Response to Submissions (RtS) Comments 12 and 15 November 2021

Scale	1 : 500@A1	Date	19/11/21
Drawn By	LL	Checked By	AF
Project No	19038	Revision	G
Drawing No	CHW-AR-DG-PSB-SSD011

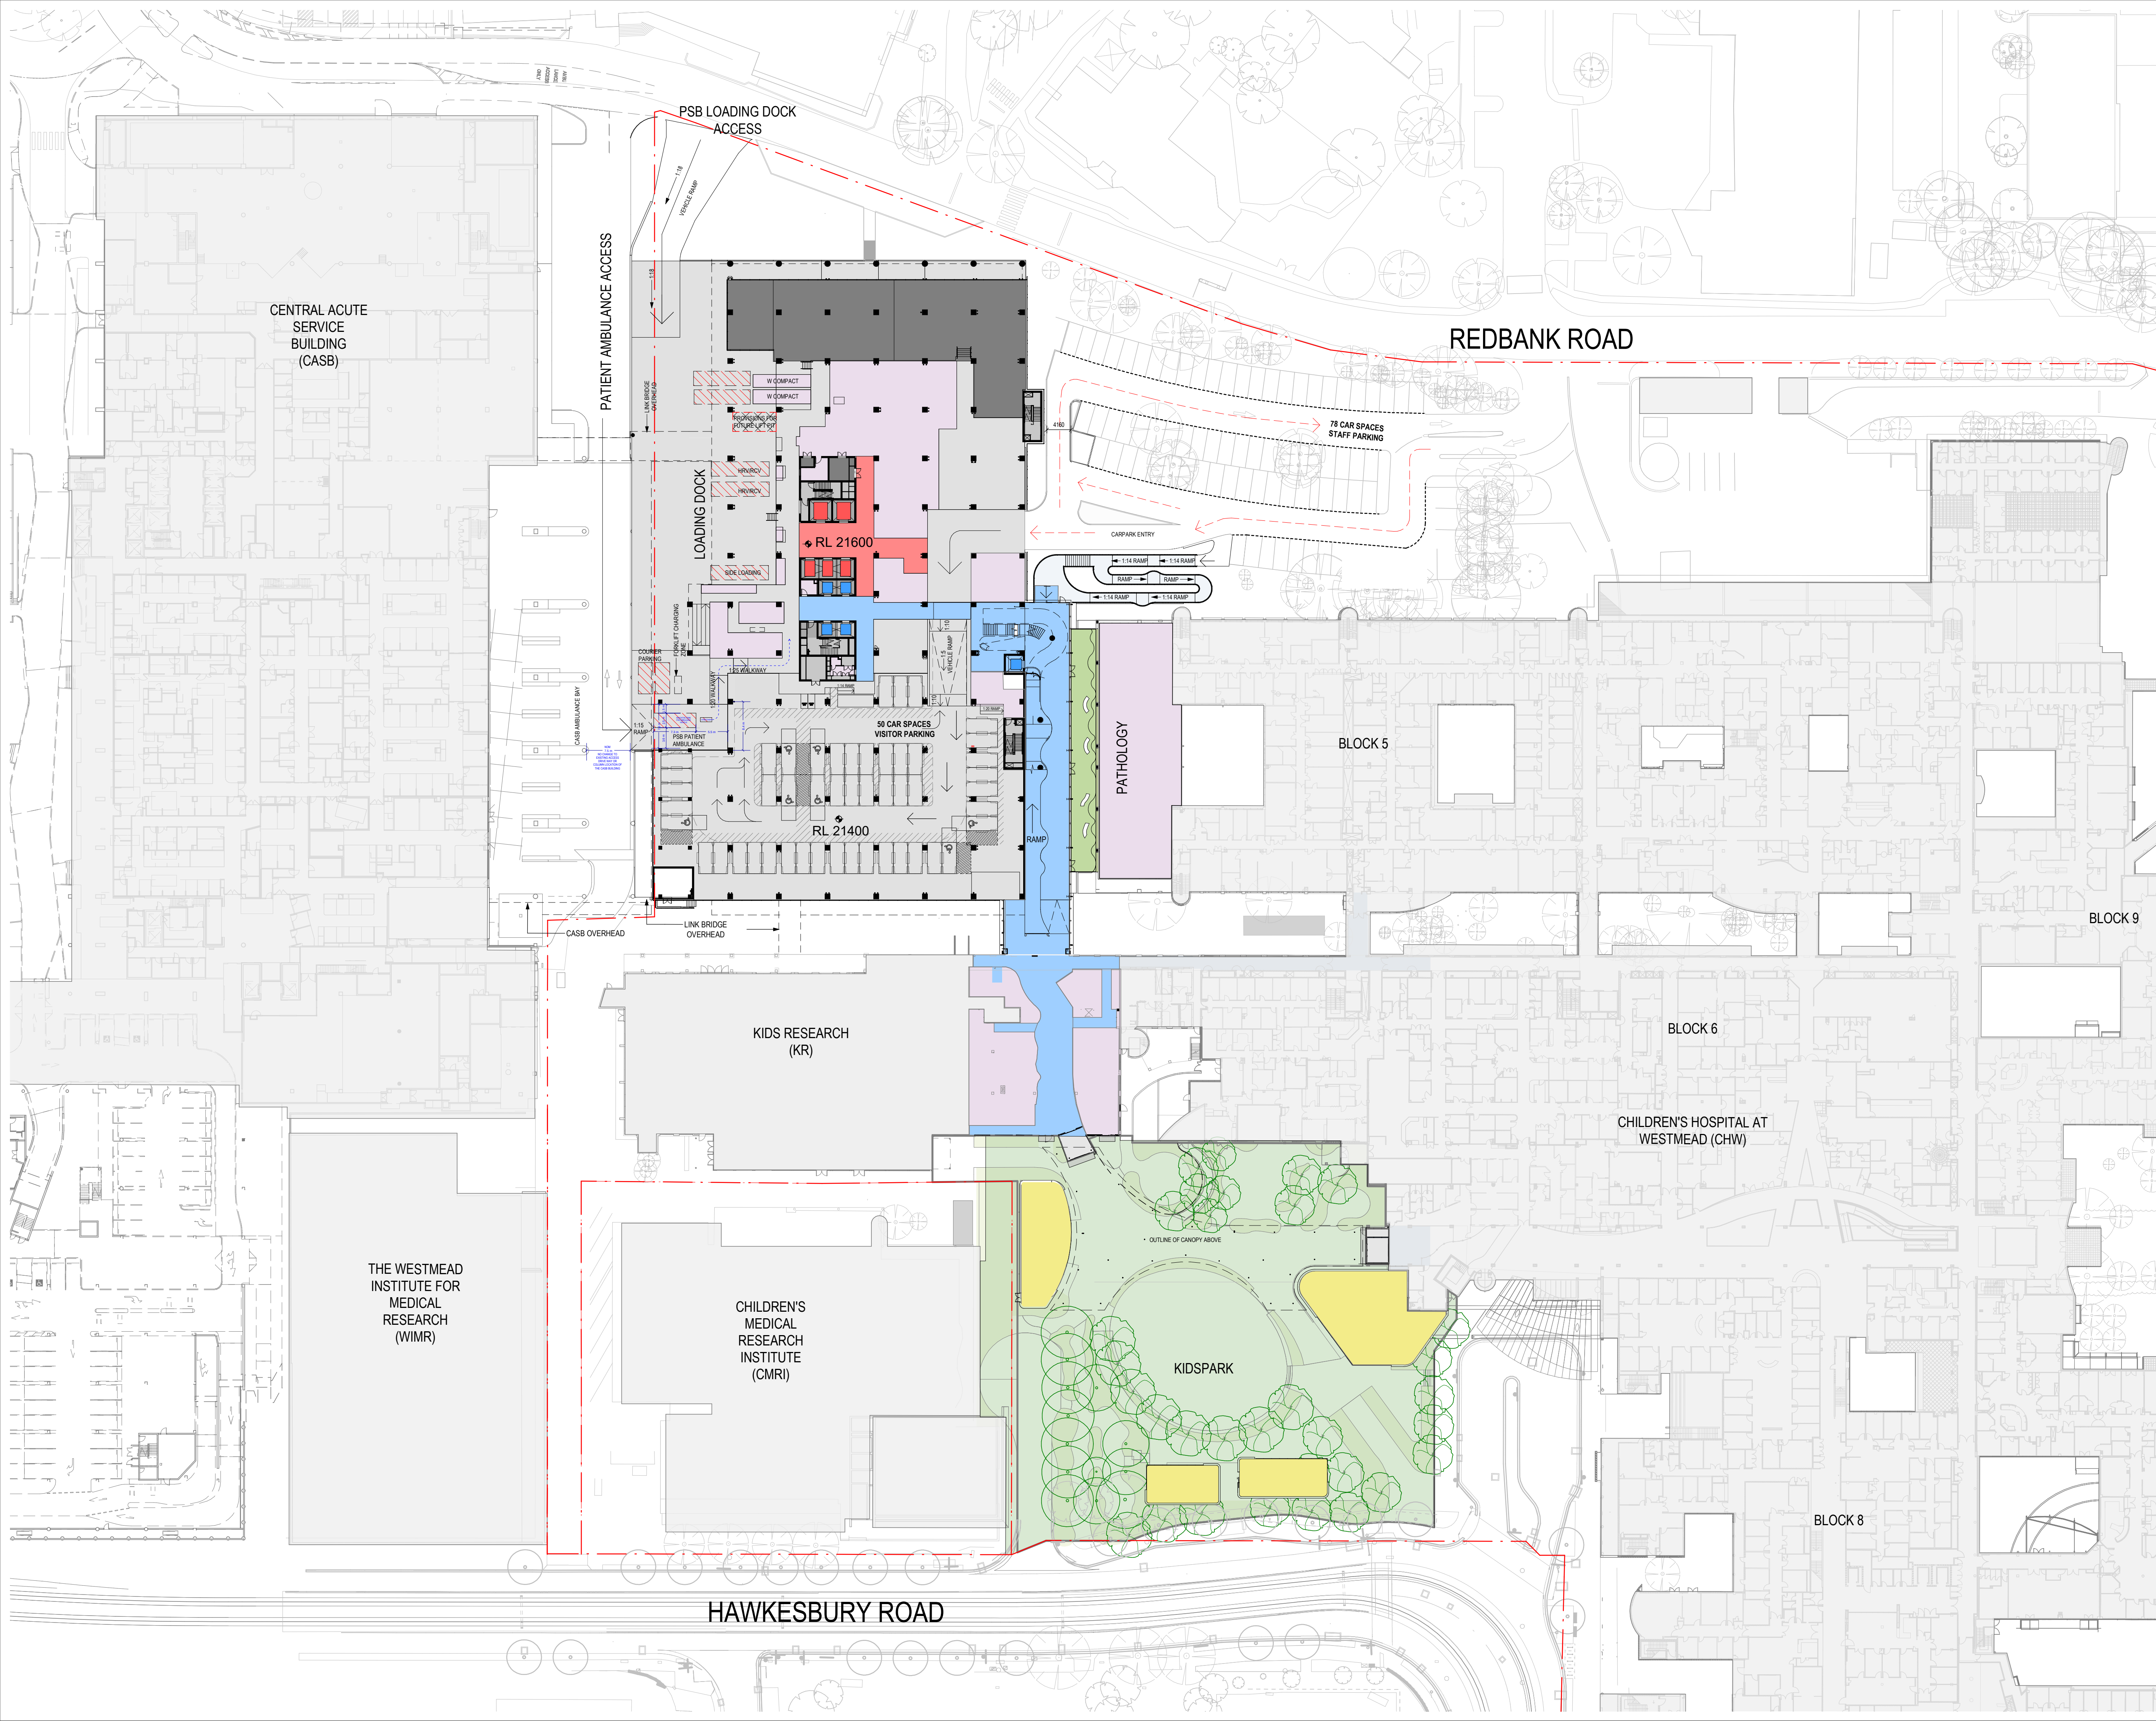
12	<p>It is noted that the plans submitted (Dwg No. CHW-AR-DG-PSB-SSD011 Rev E) appears to show a concrete median proposed close to the cul-de-sac at the end of the driveway. It is recommended that the concrete median be removed to facilitate loading manoeuvres.</p>	<p>The architectural drawings have been updated to reflect the removal of the median island.</p>

Sheet Name ELEVATIONS - SHEET 02		
Scale 1 : 500@A1	Date 19/11/21	
Drawn By LL	Checked By AF/IKK	Revision H
Project No	19038	
Drawing No CHW-AR-DG-PSB-SSD031

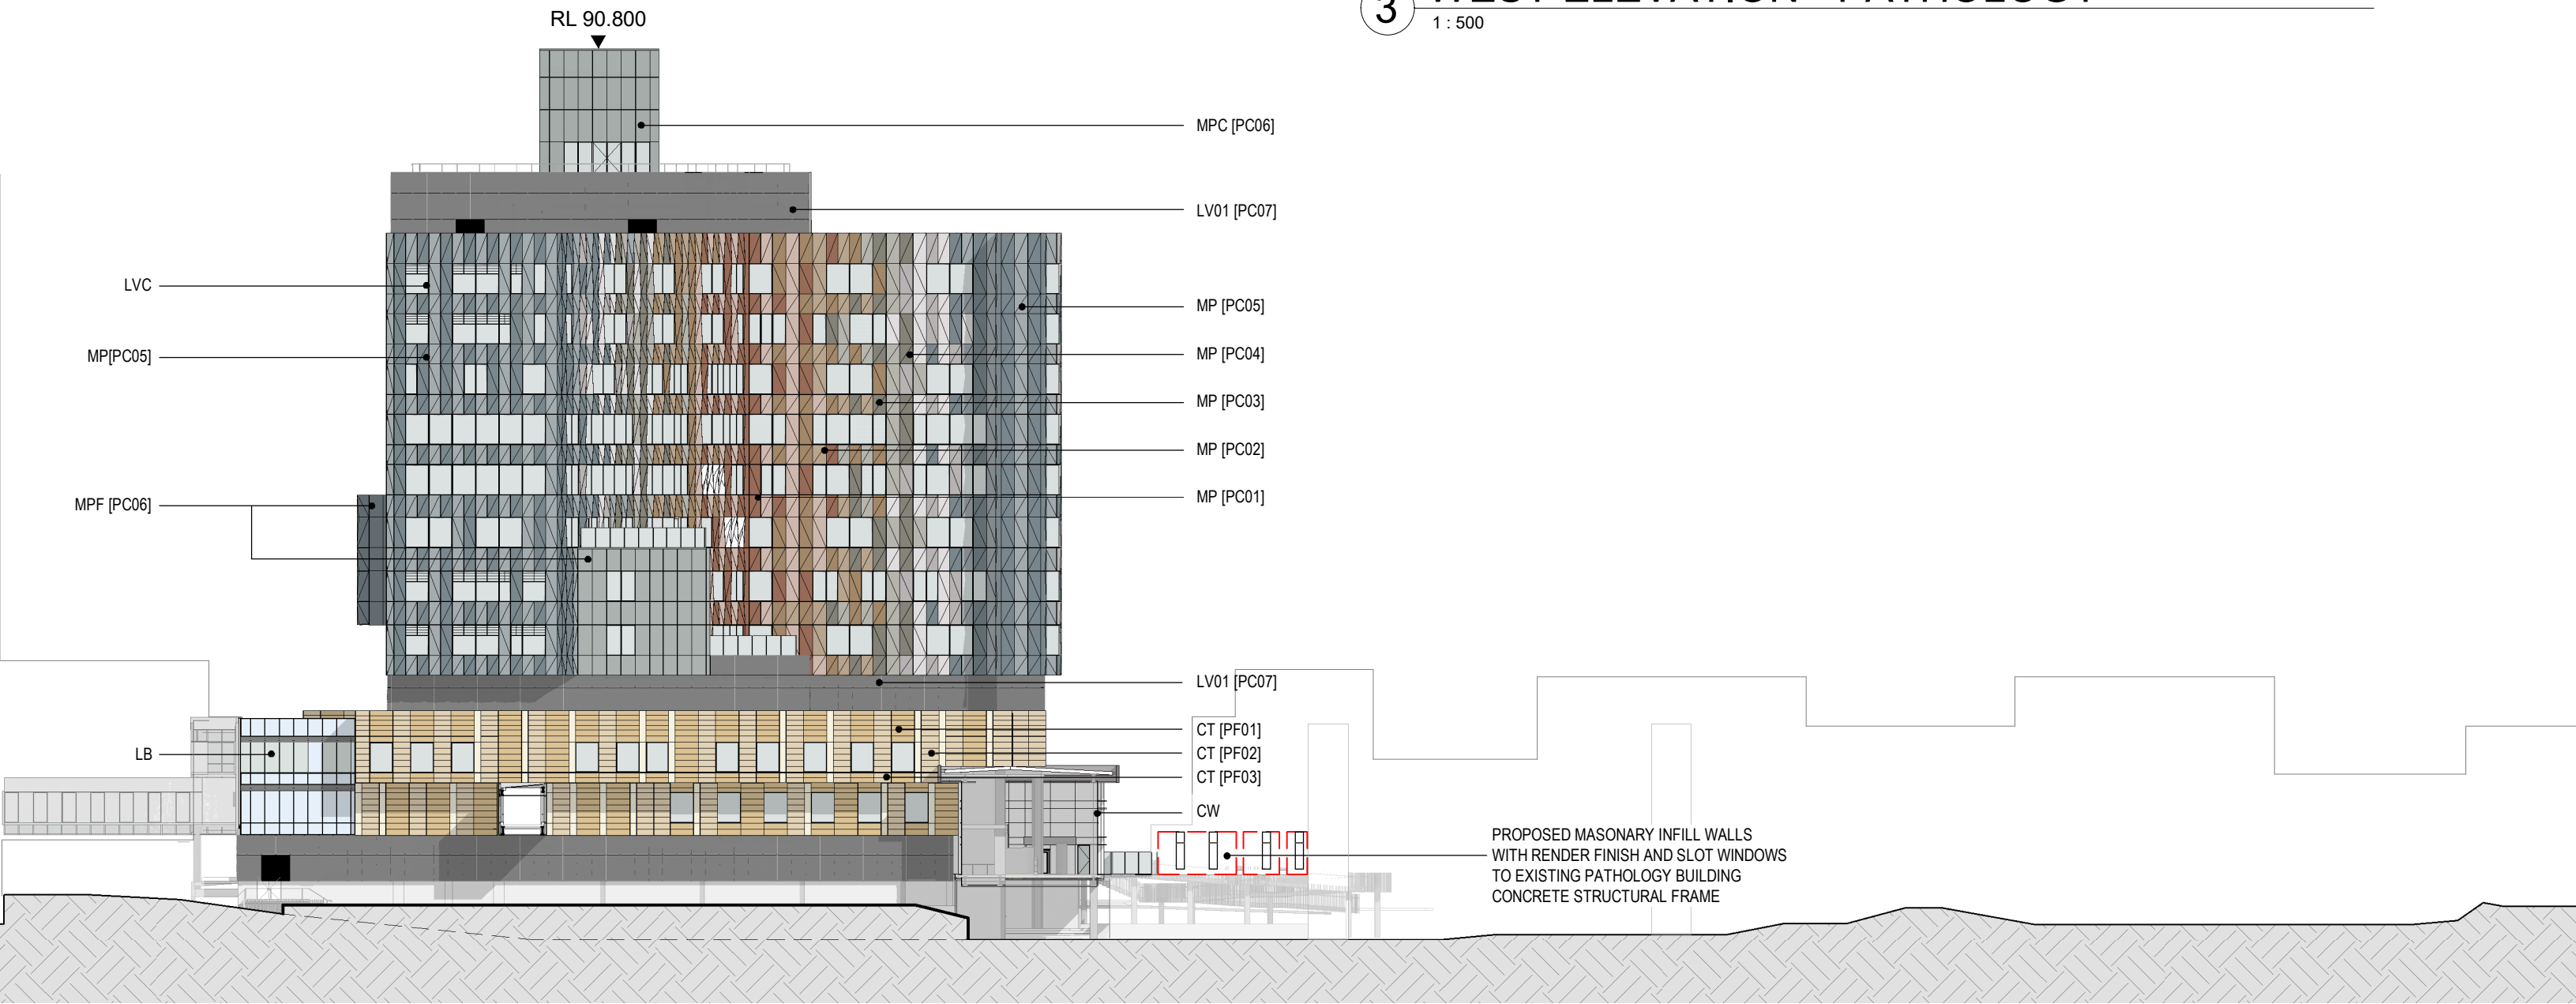
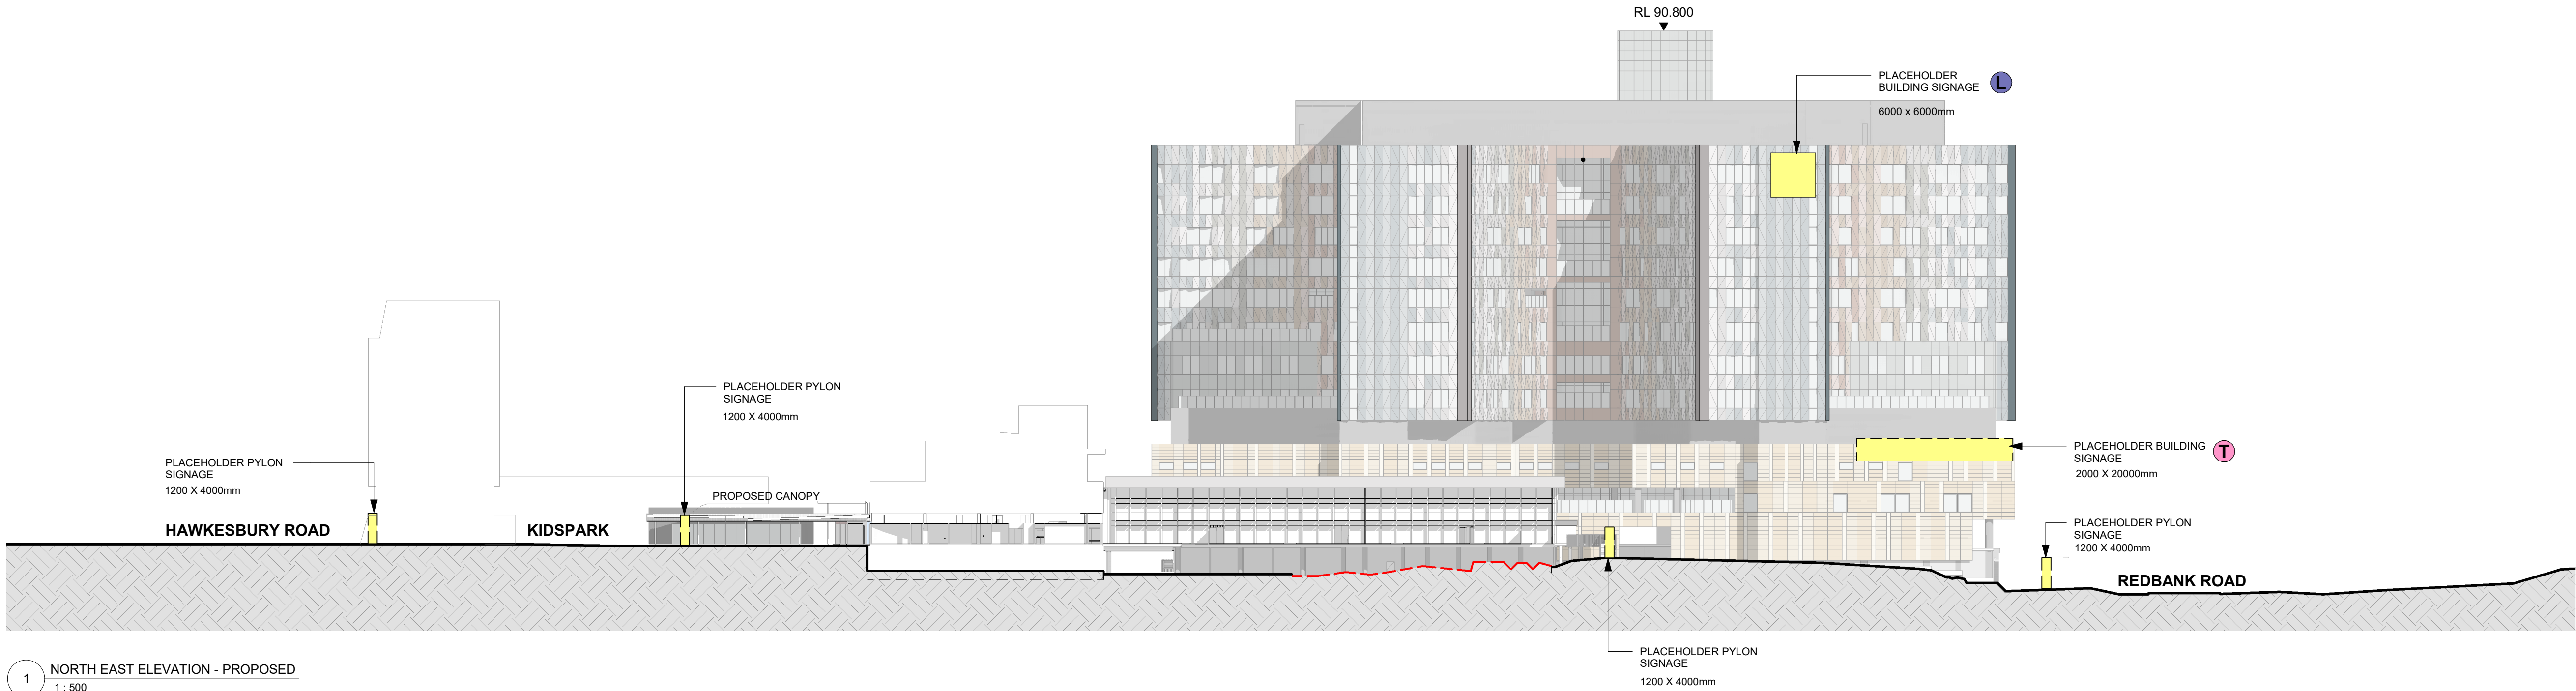
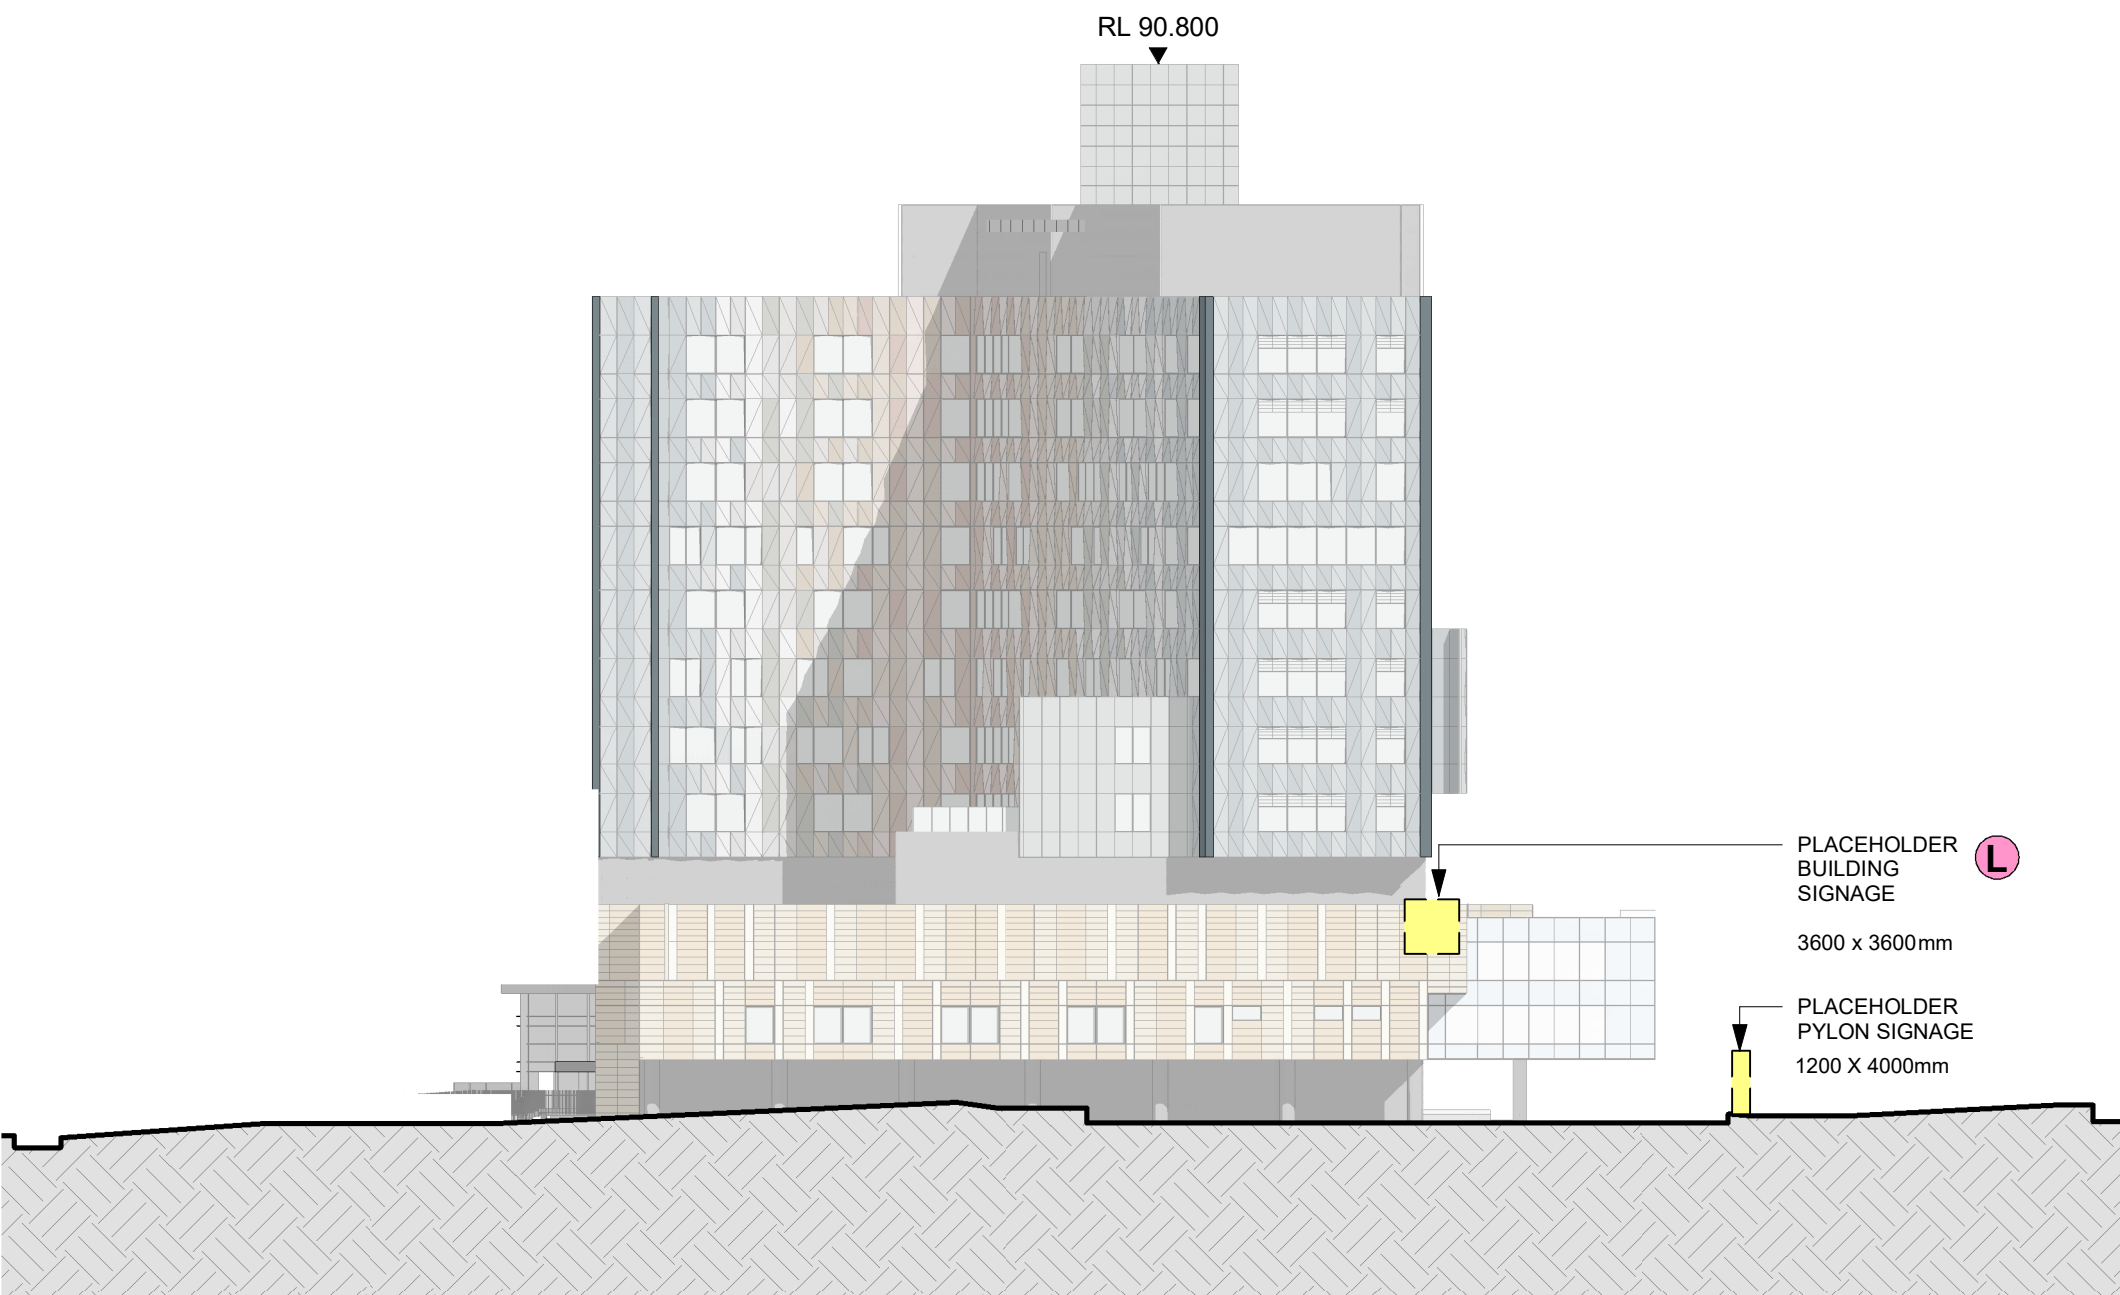
31	<p>provide updated architectural plans showing a consistent building height - the elevations currently detail a maximum building height of RL90.800, while the floor plans and Amendment Report detail a maximum building height of RL90.750.</p>	<p>The architectural documentation has been updated to reflect a consistent RL of 90.800 and removal of the median island including:</p> <p>CHW-AR-DG-PSB-SSD004-01 SITE PLAN - DEMOLITION CHW-AR-DG-PSB-SSD005 SITE PLAN - PROPOSED CHW-AR-DG-PSB-SSD011 PROPOSED PLAN - LEVEL 02 CHW-AR-DG-PSB-SSD012 PROPOSED PLAN - LEVEL 03 CHW-AR-DG-PSB-SSD013 PROPOSED PLAN - LEVEL 04 CHW-AR-DG-PSB-SSD014 PROPOSED PLAN - LEVEL 05 CHW-AR-DG-PSB-SSD015 PROPOSED PLAN - LEVEL 06 CHW-AR-DG-PSB-SSD016 PROPOSED PLAN - LEVEL 07 CHW-AR-DG-PSB-SSD017 PROPOSED PLAN - LEVEL 08 CHW-AR-DG-PSB-SSD018 PROPOSED PLAN - LEVEL 09 CHW-AR-DG-PSB-SSD019 PROPOSED PLAN - LEVEL 10 CHW-AR-DG-PSB-SSD020 PROPOSED PLAN - LEVEL 11 CHW-AR-DG-PSB-SSD021 PROPOSED PLAN - LEVEL 12 CHW-AR-DG-PSB-SSD022 PROPOSED PLAN - LEVEL 13 CHW-AR-DG-PSB-SSD023 PROPOSED PLAN - LEVEL 14 CHW-AR-DG-PSB-SSD024 PROPOSED PLAN - LEVEL 15 CHW-AR-DG-PSB-SSD025 PROPOSED PLAN - LEVEL 16 CHW-AR-DG-PSB-SSD027 PLAN - FORECOURT RETAIL & CANOPY CHW-AR-DG-PSB-SSD028 ROOF PLAN - FORECOURT RETAIL & CANOPY CHW-AR-DG-PSB-SSD040- SITE PLAN - SOLAR STUDY - SHEET 01 CHW-AR-DG-PSB-SSD041 - SITE PLAN - SOLAR STUDY - SHEET 02 CHW-AR-DG-PSB-SSD055 GFA CALCULATIONS SHEET 1 CHW-AR-DG-PSB-SSD060 VIEW ANALYSIS - PHOTO MONTAGE - RENDERS - SHEET 01</p>
